From: Fiona Fitzgerald
Sent: 10 February 2019 20:53
To: Planning.Responses
Cc: Michael Eastham
Subject: FW: Planning Consultation on WA/116/18/DOC

With respect to Condition 6 (Construction Management Plan), Environmental Health would make the following comments:

APPLICATION NO: WA/116/18/DOC

Description of Works: Approval of details reserved by condition imposed under ref WA/44/17/OUT relating to Condition No 6 Construction Management Plan and Condition No 14 construction compound.

Drawing Title:
INDICATIVE SITE SETUP PLAN

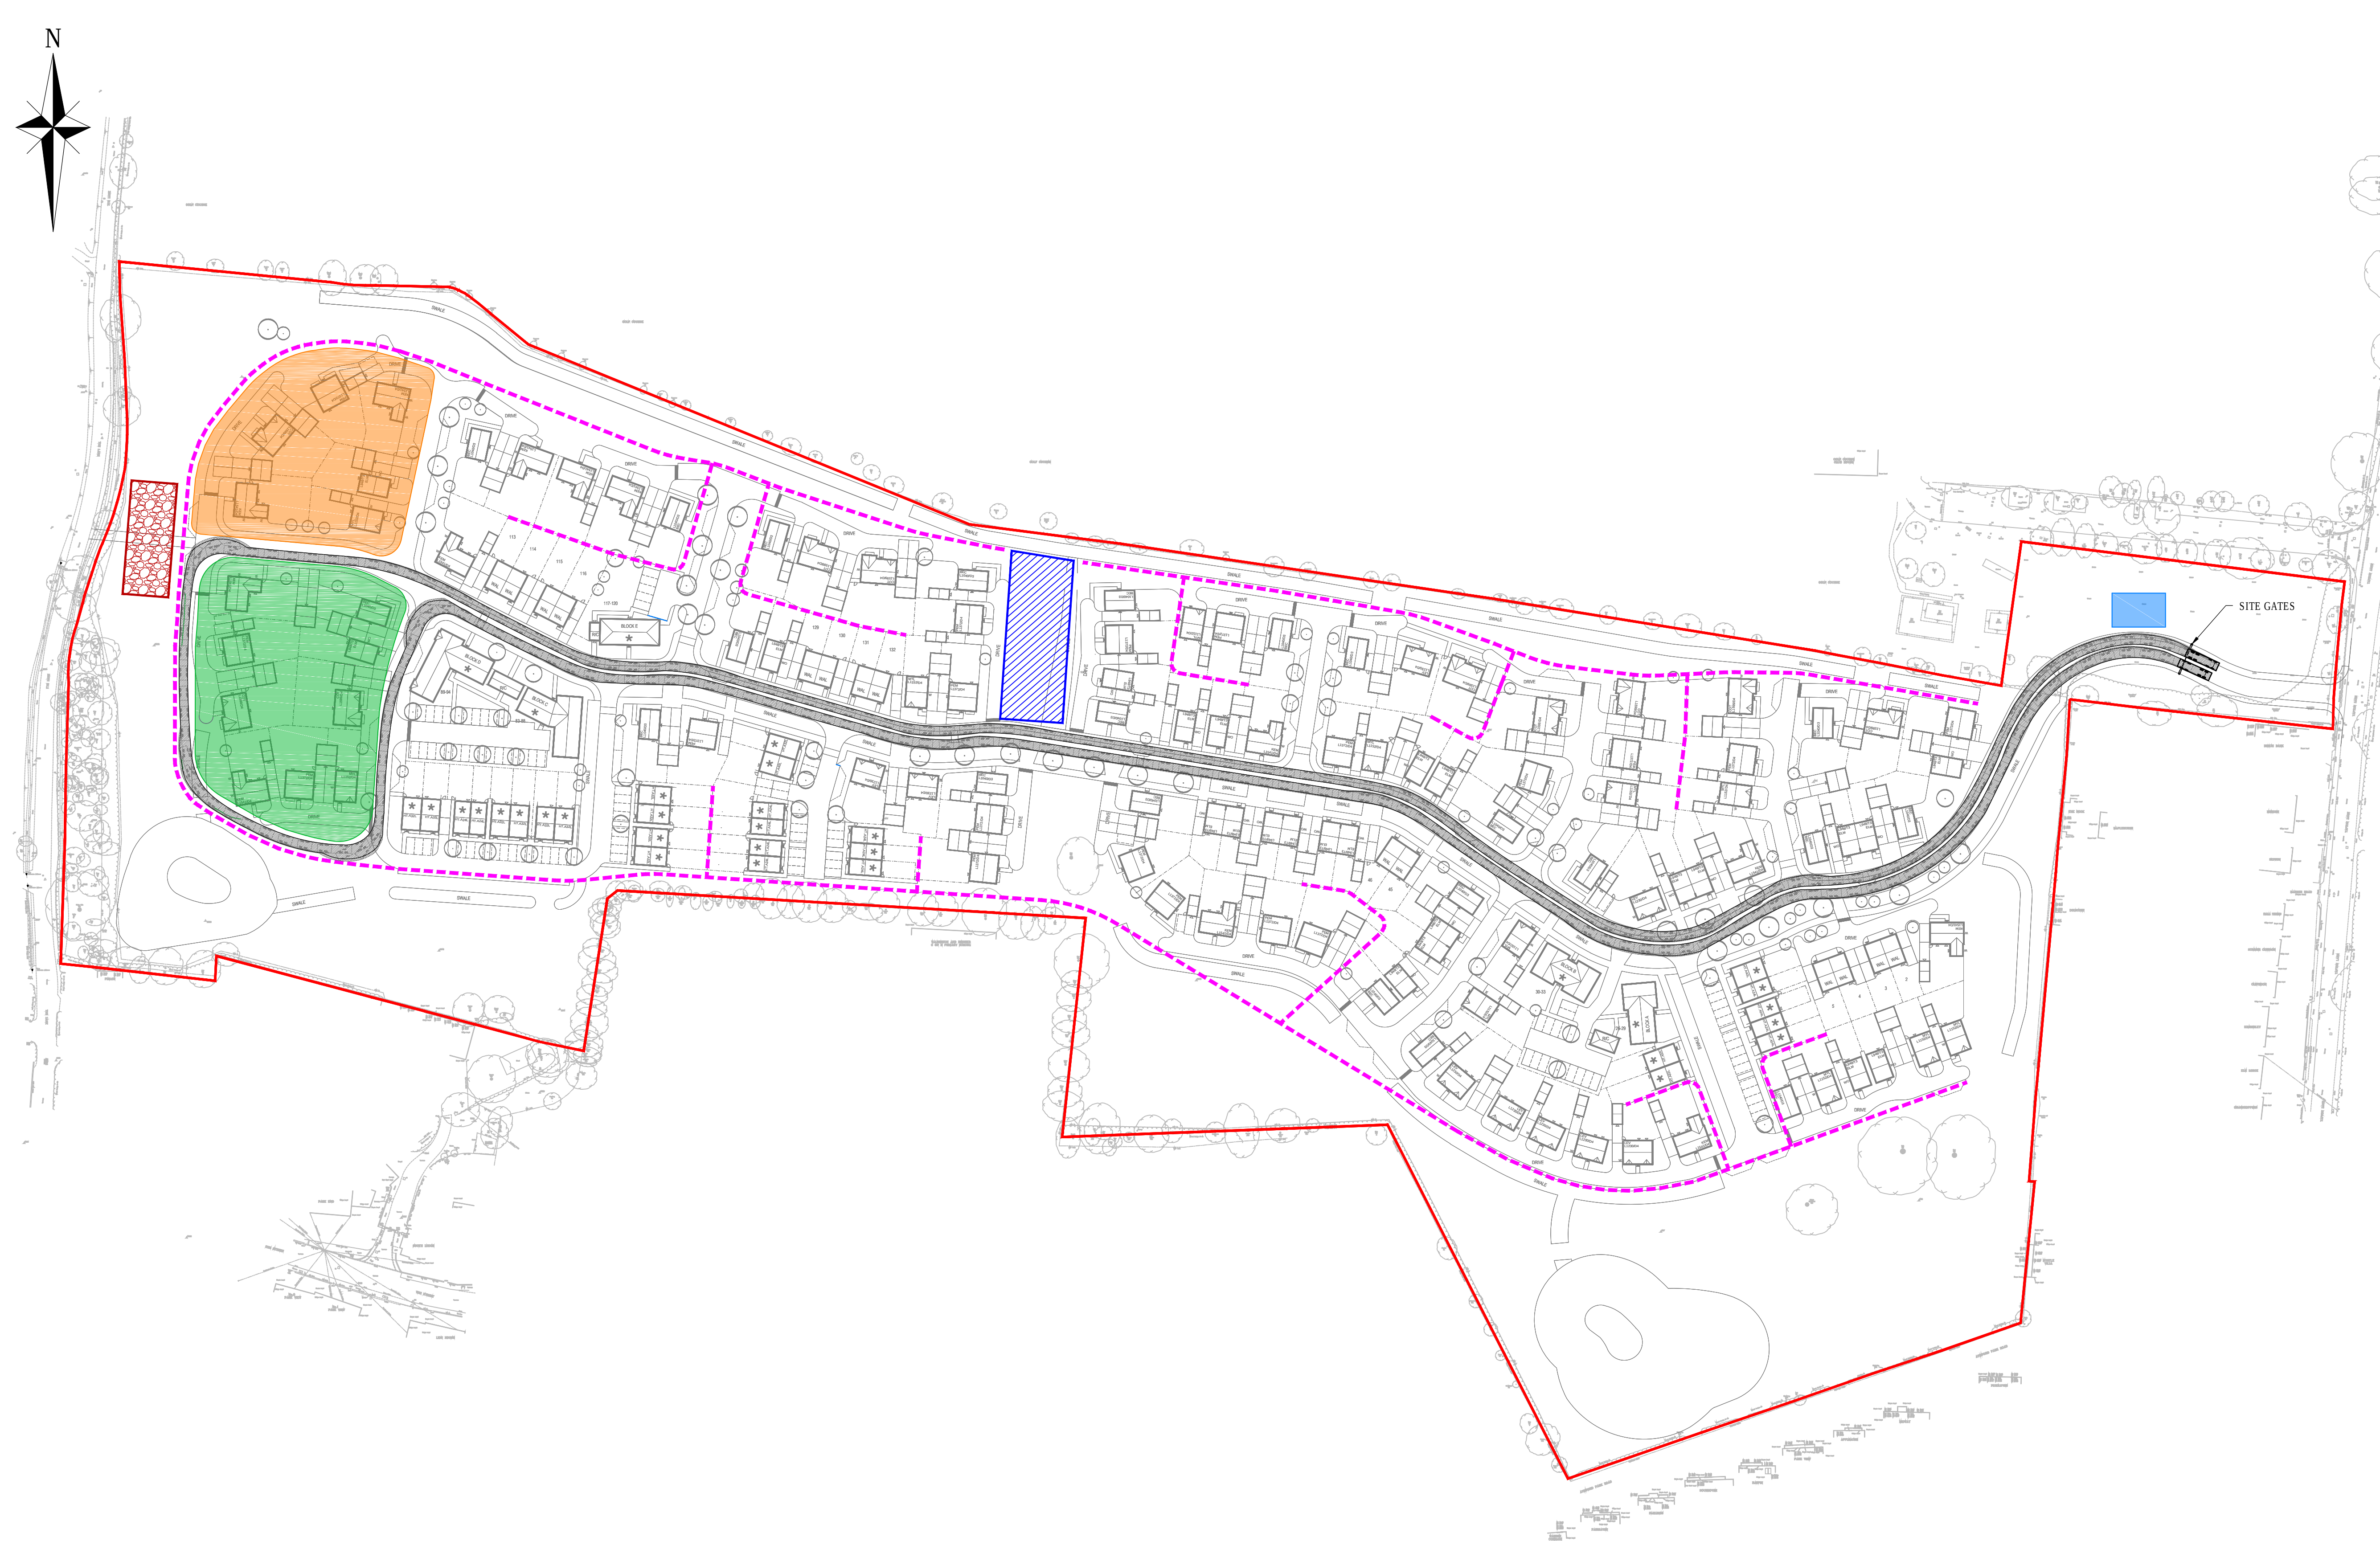
In relation to the wording of condition 6, I cannot find information on either wheel washing (although damping down is mentioned) or floodlighting. Please advise where these points are covered.
